LY/1/21/PL

St Mary Magdalene's Church, Church Lane, Lyminster, BN17 7QH

Proposed new Klergester below ground cesspool for existing Church WC facilities. This application may affect the setting of a listed building, may affect the character & appearance of the Lyminster Conservation Area & is in CIL Zone 3 (Zero Rated) as other development.

Sketch plan showing location of cesspool storage tank
1:100

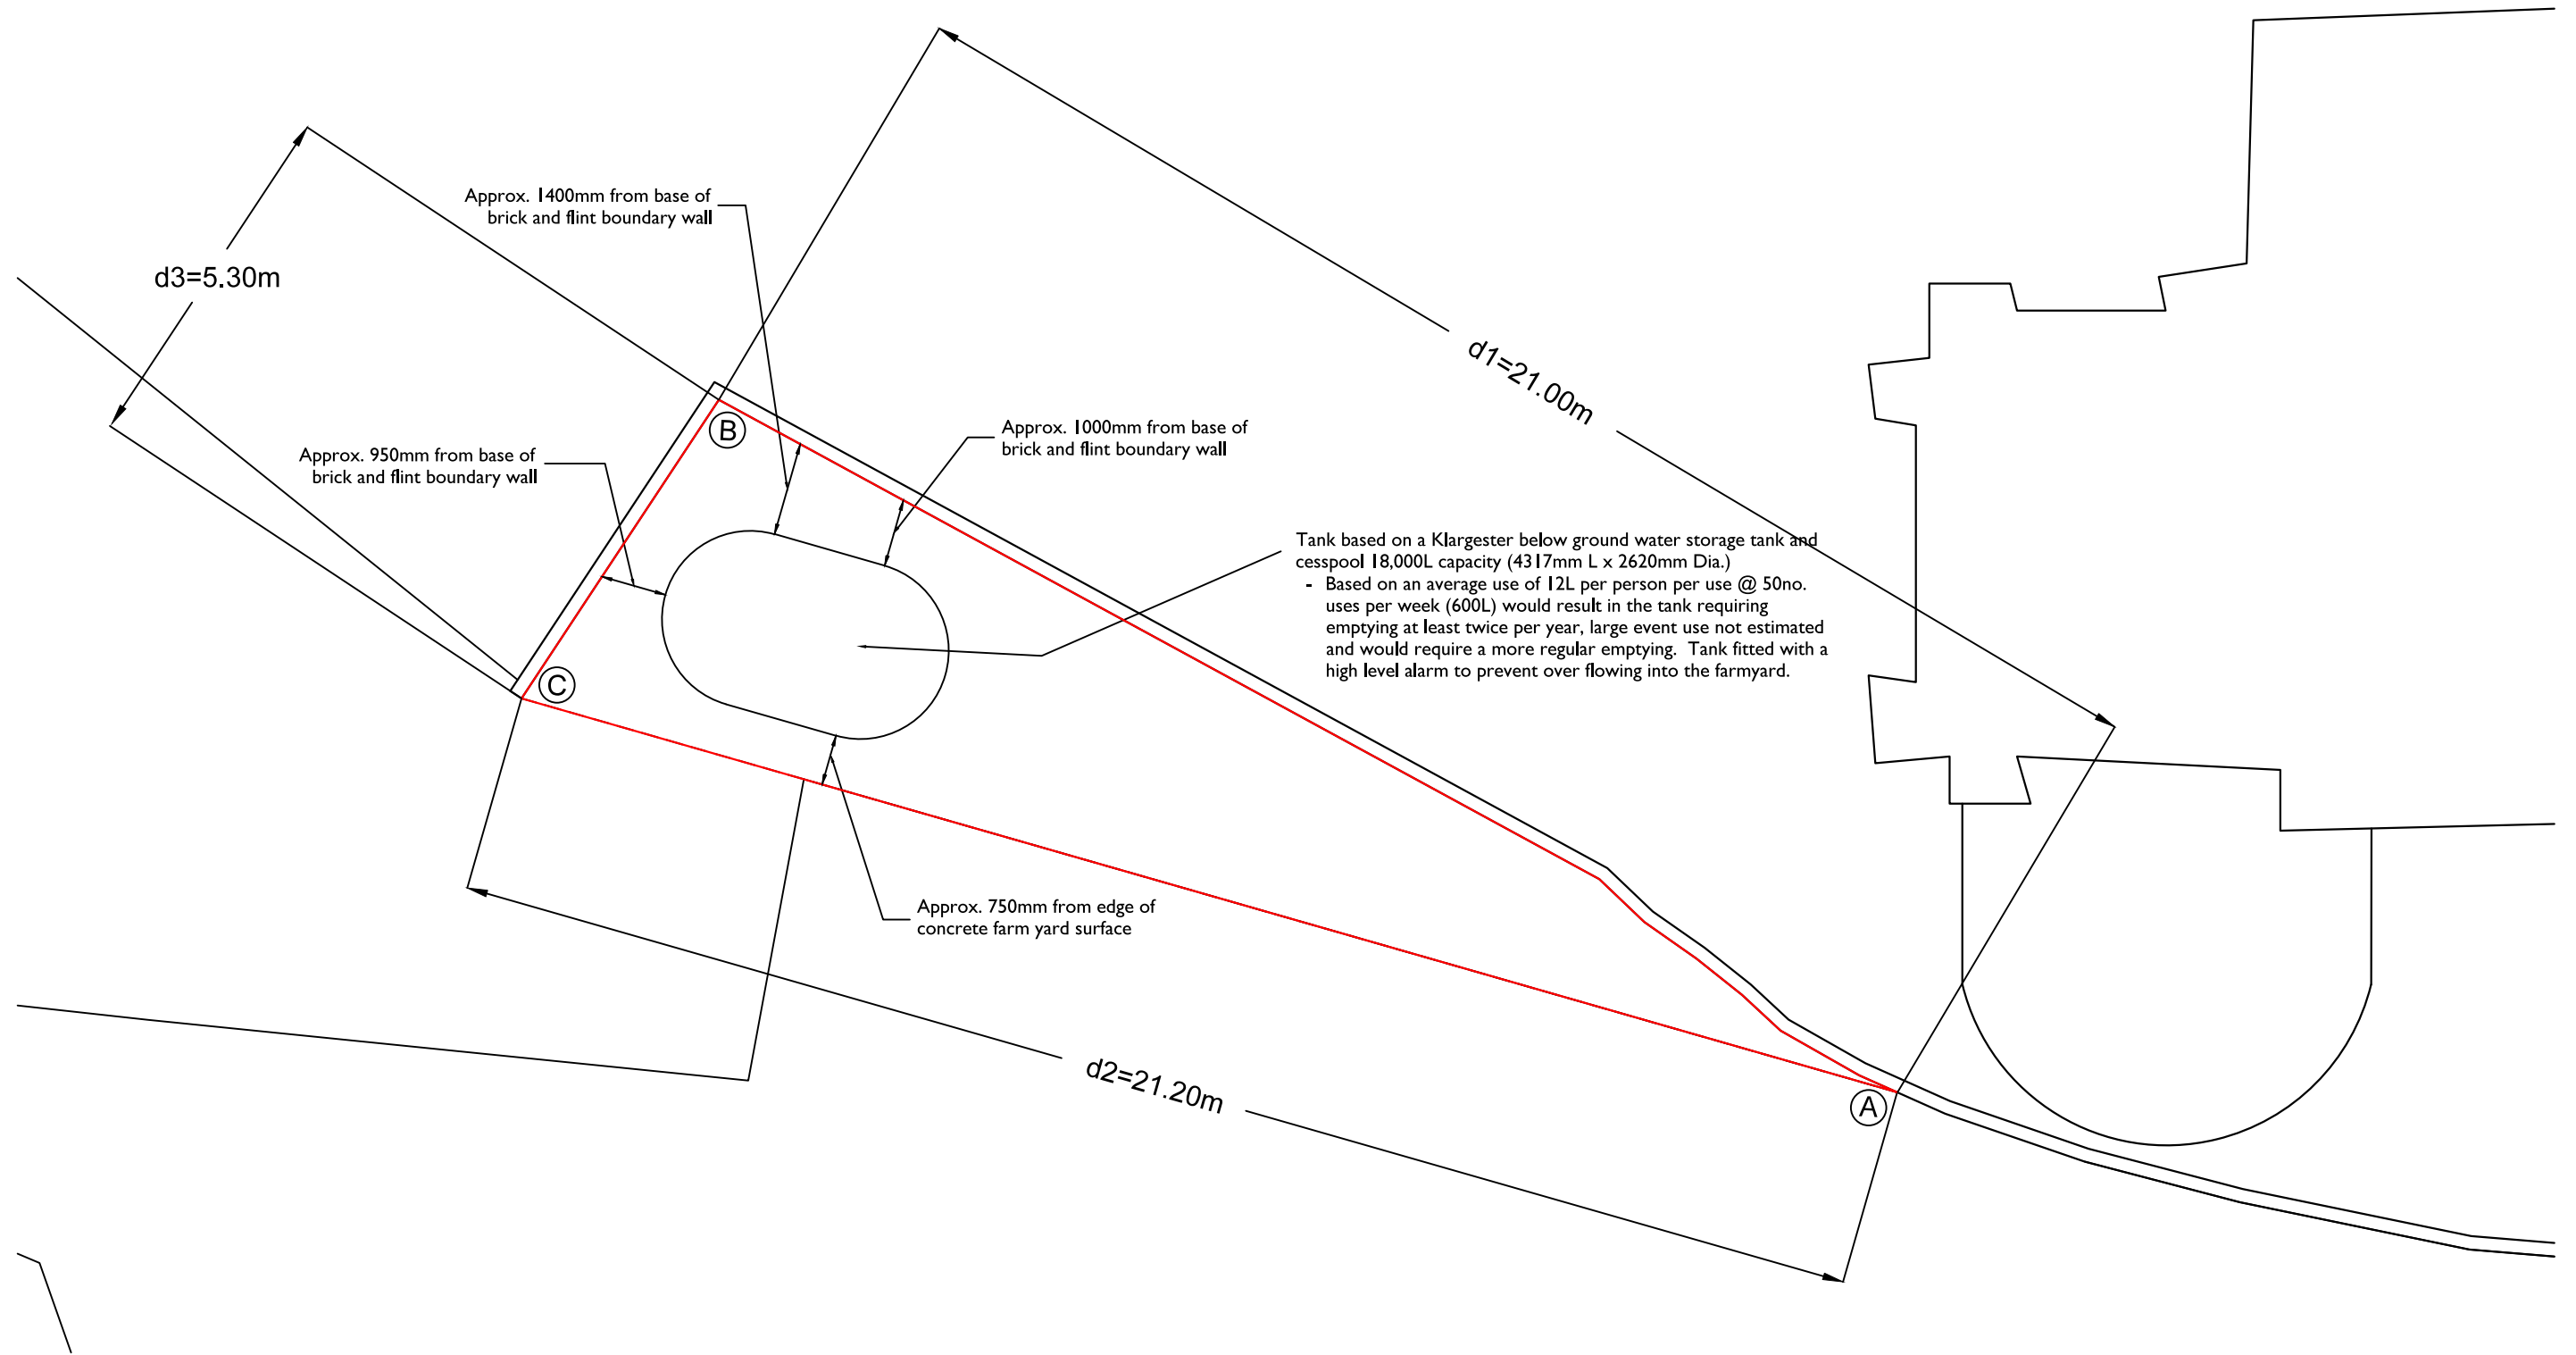
The proposal is for a new Klergester below ground cesspool for existing Church WC facilities. The Klergester will be located adjacent to the churchyard within a small triangular parcel of land alongside a farmyard track of Church Farm north of some modern agricultural barns.

It will be located in close proximity to the church WC facilities, whilst also minimising any necessary trenching of a foul waste pipe through the archaeologically significant graveyard. Whilst this is a positive approach, I would want the council's archaeological advisor to also review the application from his specialism. I would also want to be assured that in undertaking the works that the attractive walling would not be affected during any construction works.

I note that the external appearance of the area will be returned to soil and grass with only a simple man-hole cover for emptying and maintenance being visible. The introduction of grass will improve the appearance of the land.
